Your Ref: 23/01316/F

Erection of 5 two storey age restricted dwellings (55 years) for older people with access, landscaping and associated infrastructure - Land South of Faraday House, Woodway Road, Sibford Ferris (Application No. 23/01316/F)

**Figure 4 – Proposed Site Plan**

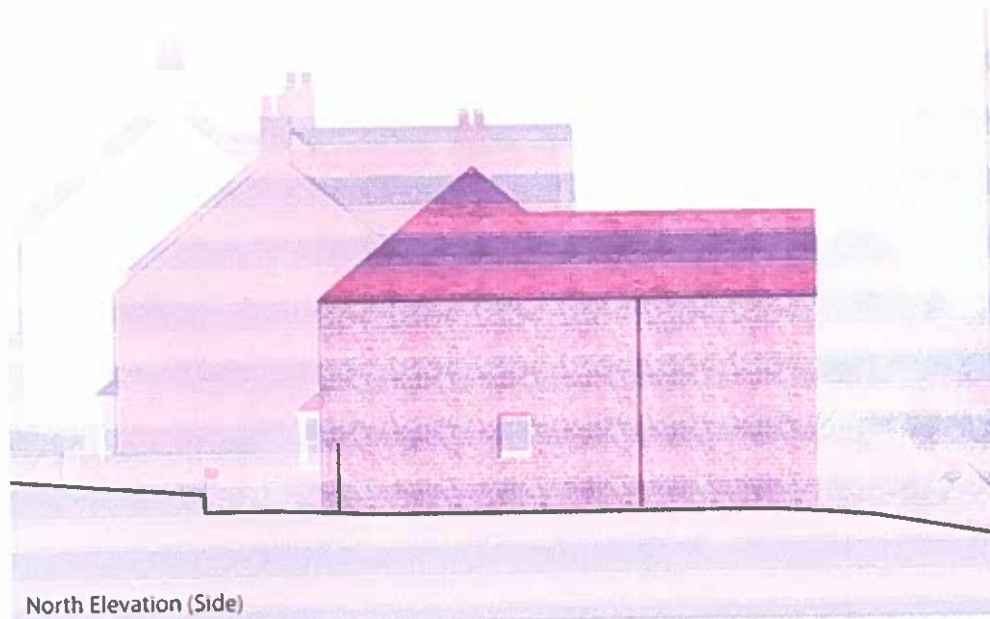
In this particular case, the amended proposal with two-storey dwellings will be accessed via what will become a long access road (circa 225m) serving a total of 30 no. dwellings (i.e. the proposed 5 no dwellings and the 25 no dwellings at Hook Norton Road) running within just a few metres of the private rear gardens of existing dwellings at Woodway Road, Stewart's Court and Hook Norton Road. The use of this by residents' vehicles, visitors and service vehicles will cause noise, disturbance and intrusion into what is presently open, rural countryside with very quiet ambient noise levels, which will be detrimental to the tranquil, peaceful residential amenities of existing neighbouring properties.

The close proximity of the proposal to existing dwellings is evident from Figure 4.

Figure 6 – View of Proposal from the North (Faraday House)

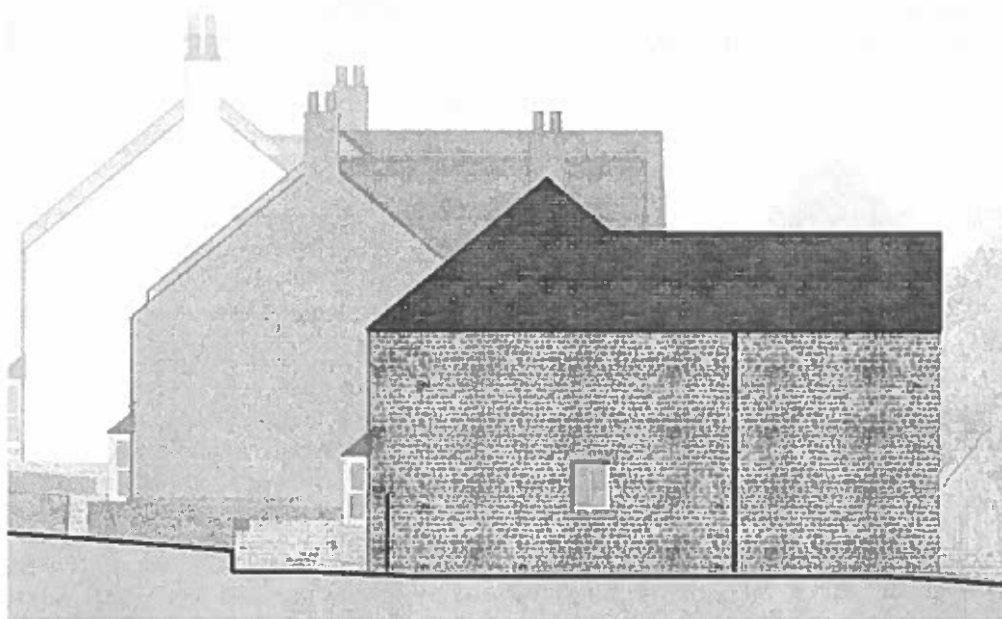
The physical impact of the dwellings – especially Plot 5 – is perhaps most acute upon Faraday House just 15 metres to the north of the site, as shown on Figure 6 taken from the application.

Where development results in prejudicial harm to the outlook of a residential property and is unduly overbearing it should be resisted as failing to achieve acceptable standards of layout, design and residential amenity and the highest possible standards of design.
